From: Denise Preisser <dpreisse@maine.rr.com>
To: Jean Fraser <JF@portlandmaine.gov>
Date: 2/6/2016 8:36 PM
Subject: Re: 31 Fore Street

Hello Jean,
Thank you for keeping me up to date on the plans of 31 Fore Street.

RETAINING WALL BUTTRESS

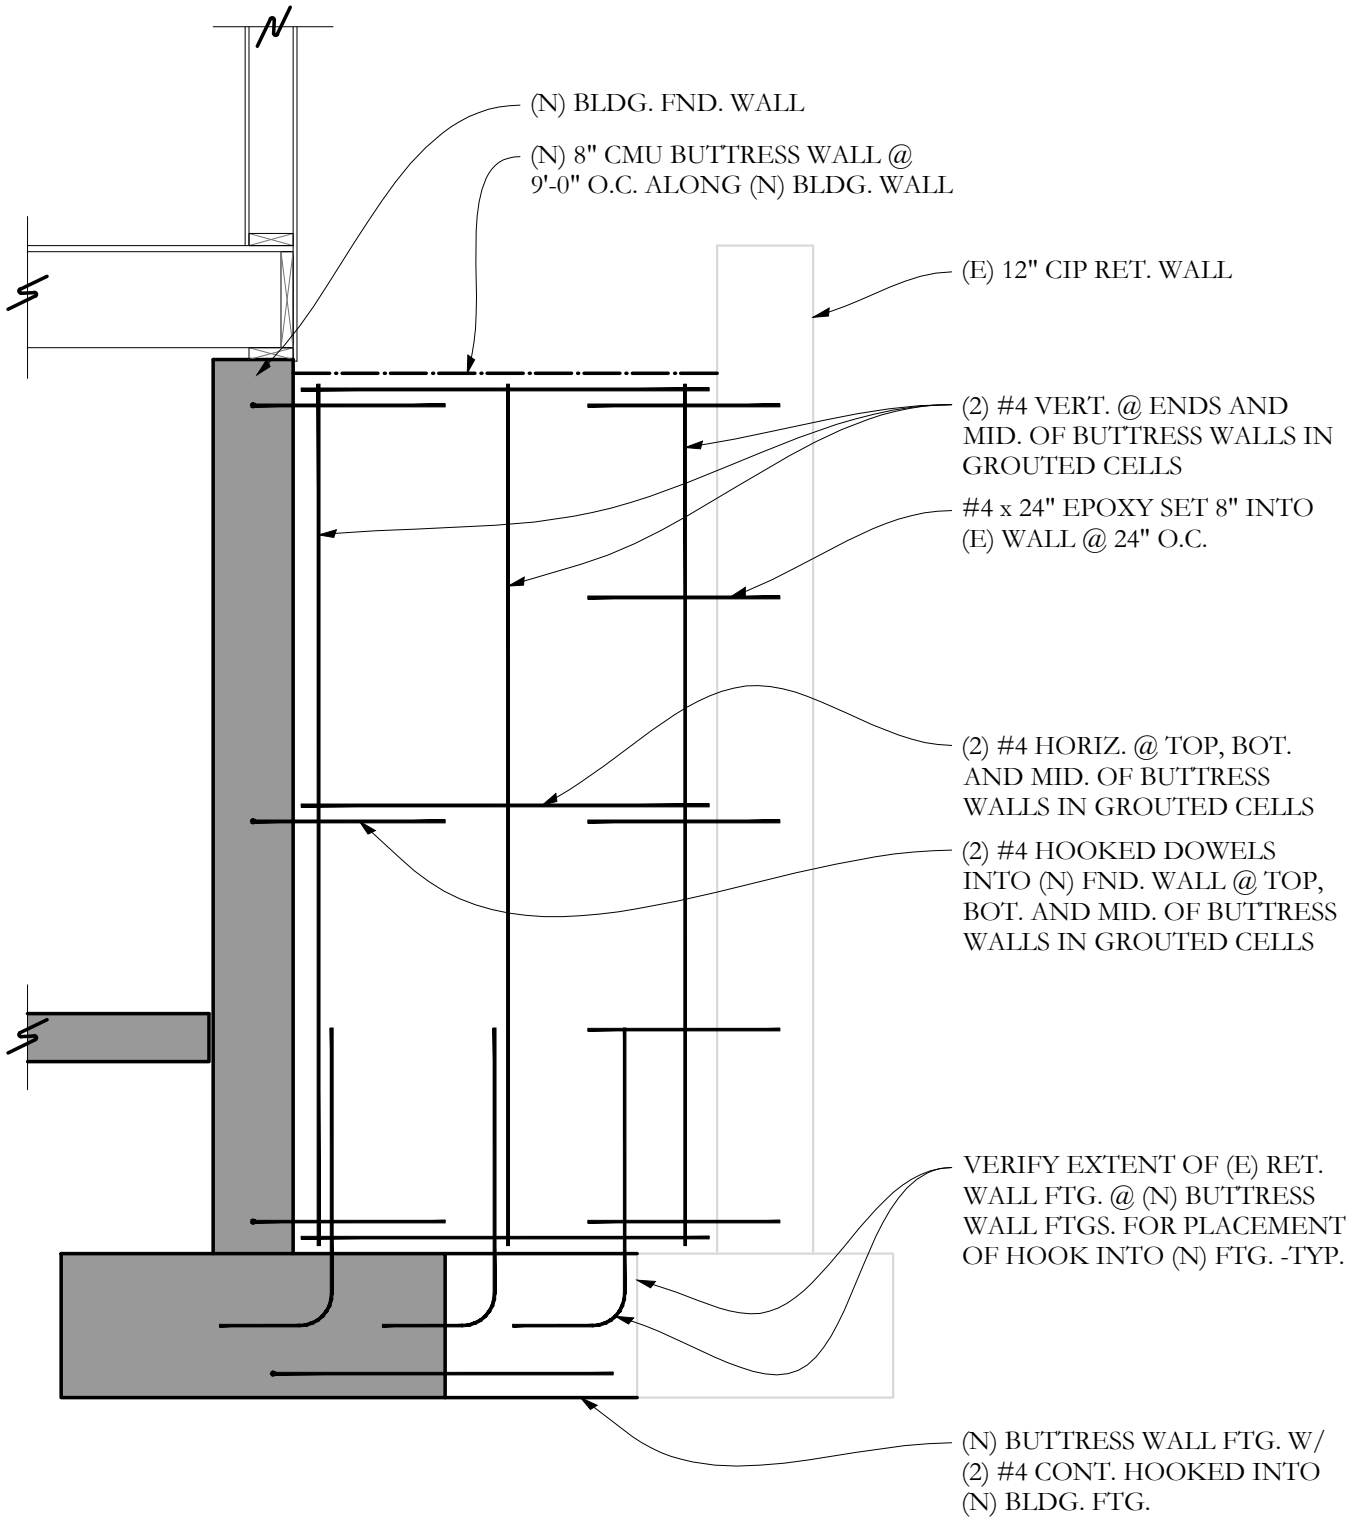
• Demolition of the current 31 Fore property in regards to protecting the 25 Fore land on the uphill side from being disturbed and to prevent damage to our building structure must be highly observed. This land disturbance could really impact our property and wondering what protections we will have to prevent this? (i.e.. The new Bay House condo development affecting surrounding property foundations.)

1 ELEVATIONS - SOUTH
SCALE: 1/4" = 1'-0"

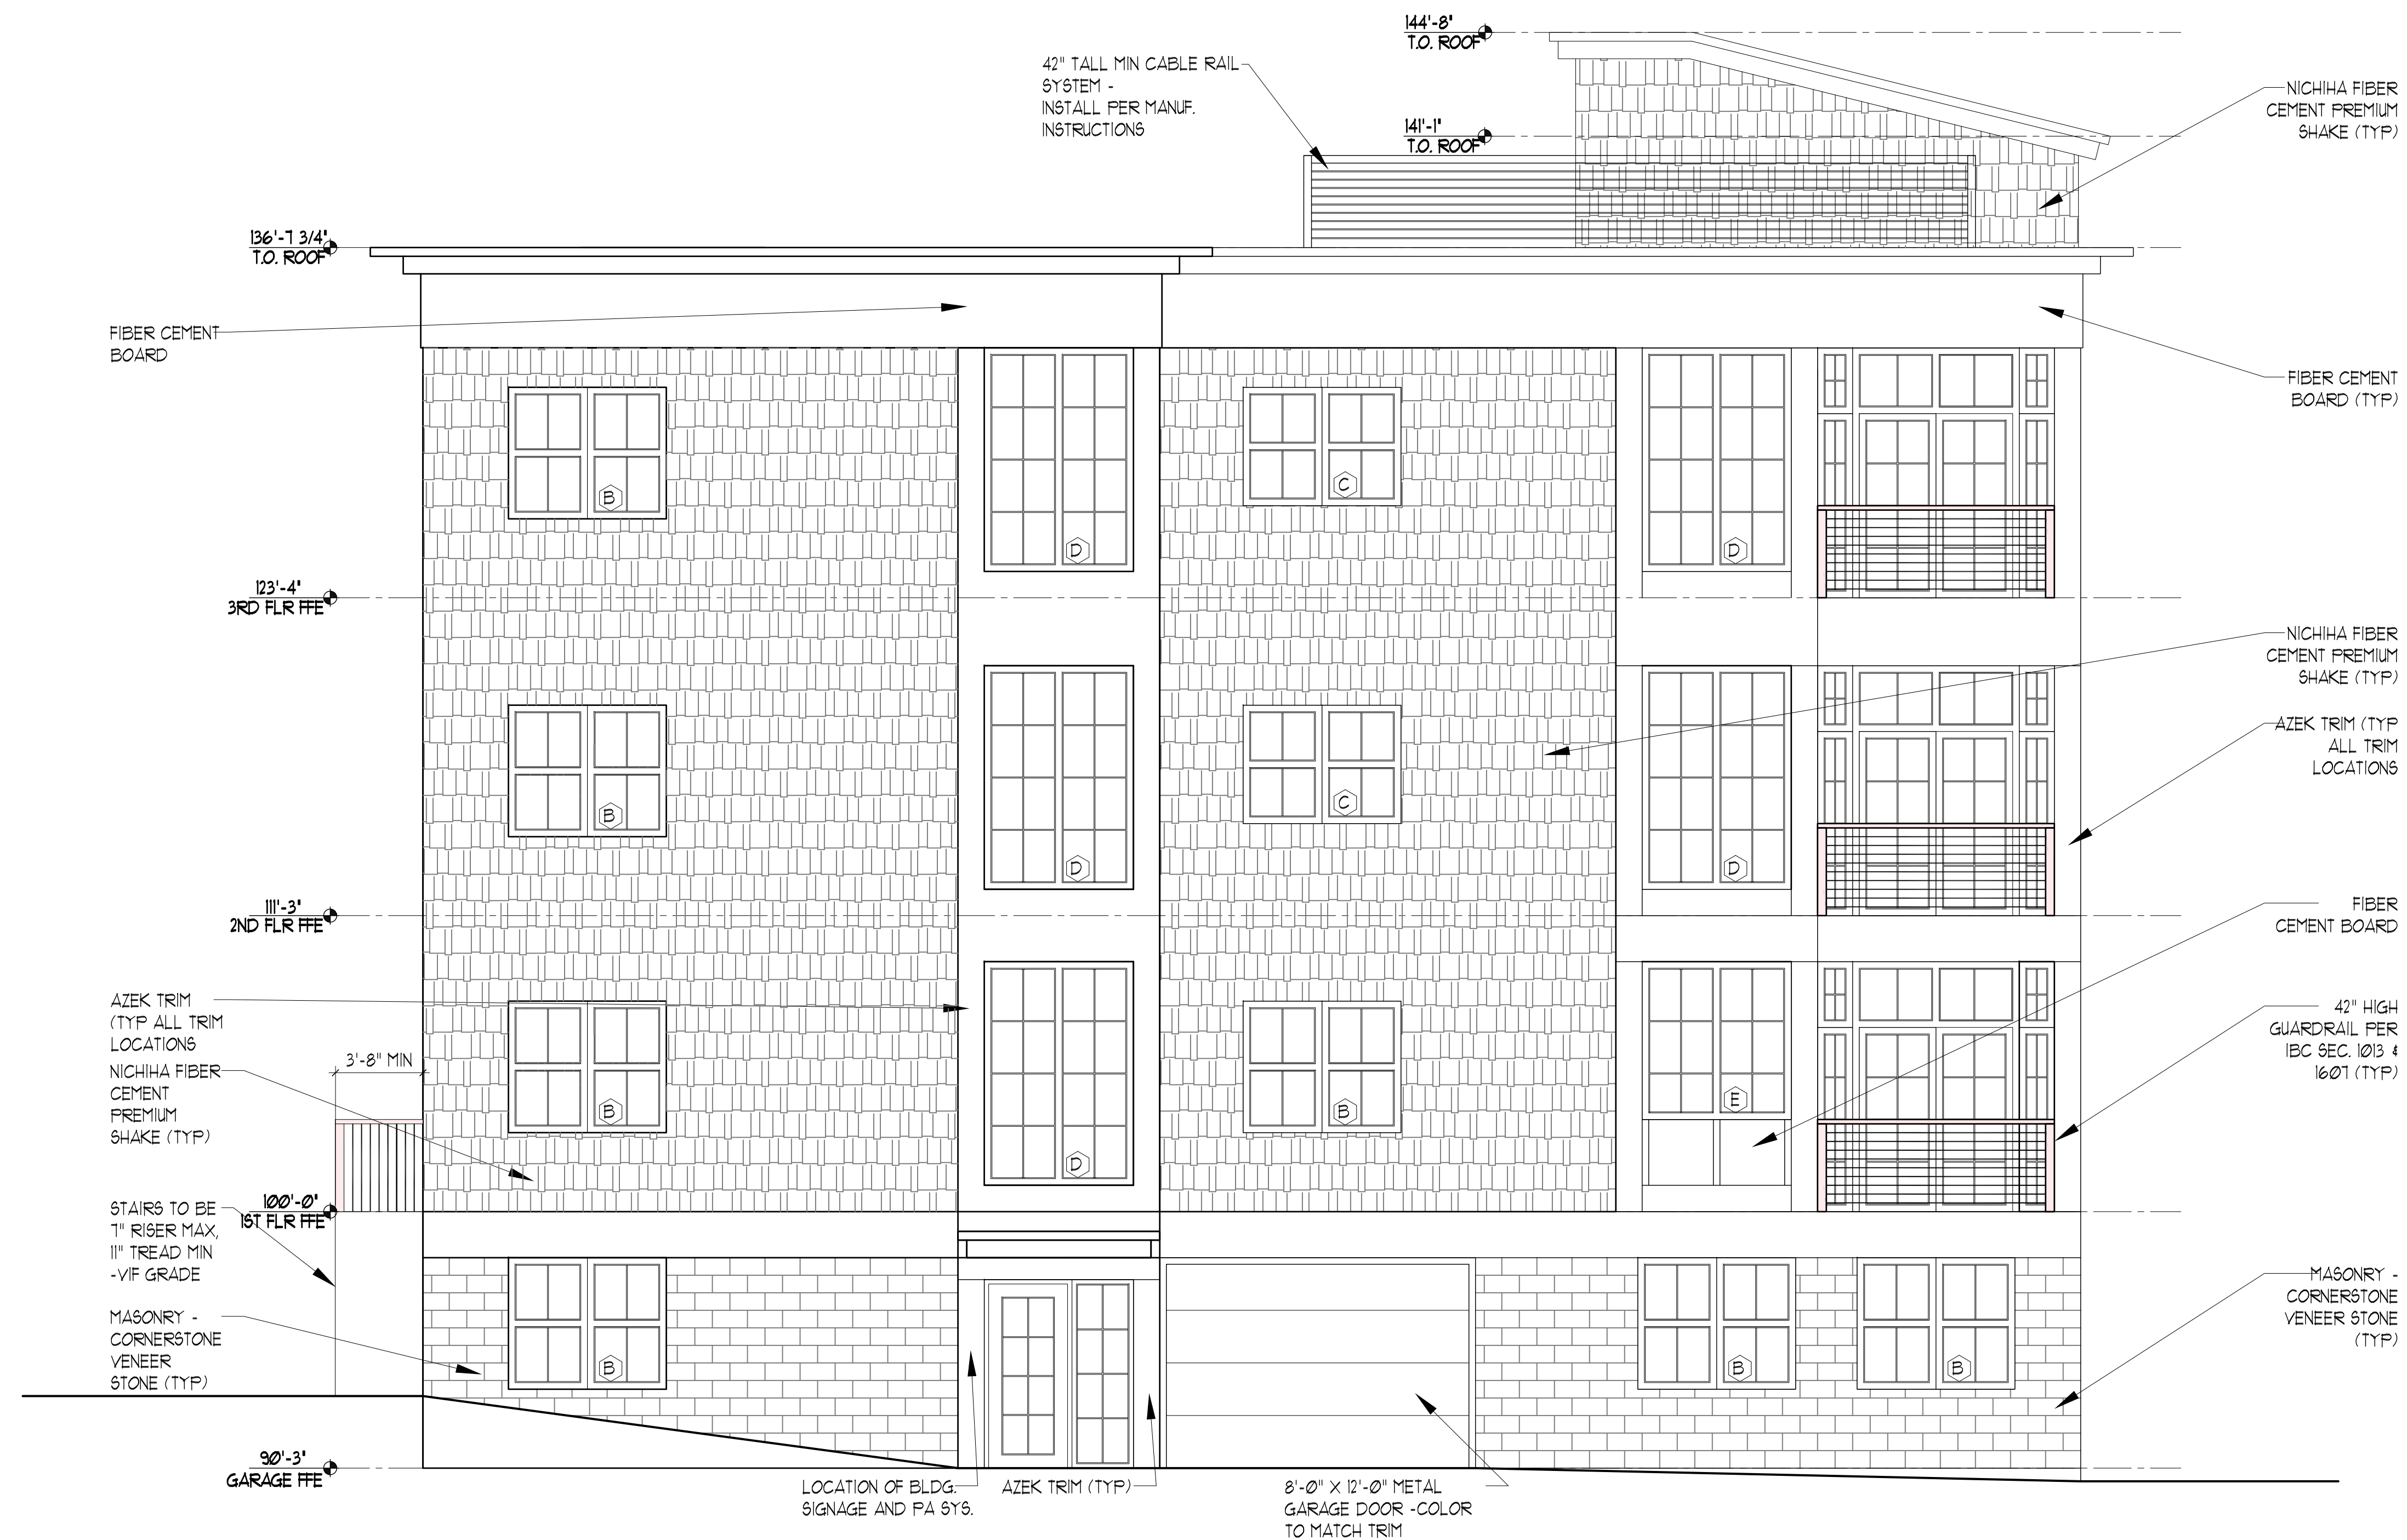
•The limited number of windows on the side of the building abutting the 25 Fore Street condo and garden pathway is a real plus. The buildings are so close and this new design provides privacy for both buildings. As I interpret the plans the windows on this side will be only be for stairs and landings for each floor.

• The visitor/delivery entrance abutting 25 Fore Street property line does not seem to be an effective screening for privacy for 25 Fore decks and garden area. At this time our space is gated for security and privacy and this plan looks like anyone could walk up this side entrance and have access to our property. I want to make sure the developer makes provisions to compliment both properties, but also maintain the privacy and security for 25 Fore property that now exists. My first choice would be not to have an entrance on this side however, if that can not be addressed, I suggest fencing be added to define secure our property lines (like we currently have) and/or vegetation added that enhances the 5 foot space to be added the length of the building with the new footprint of this building.
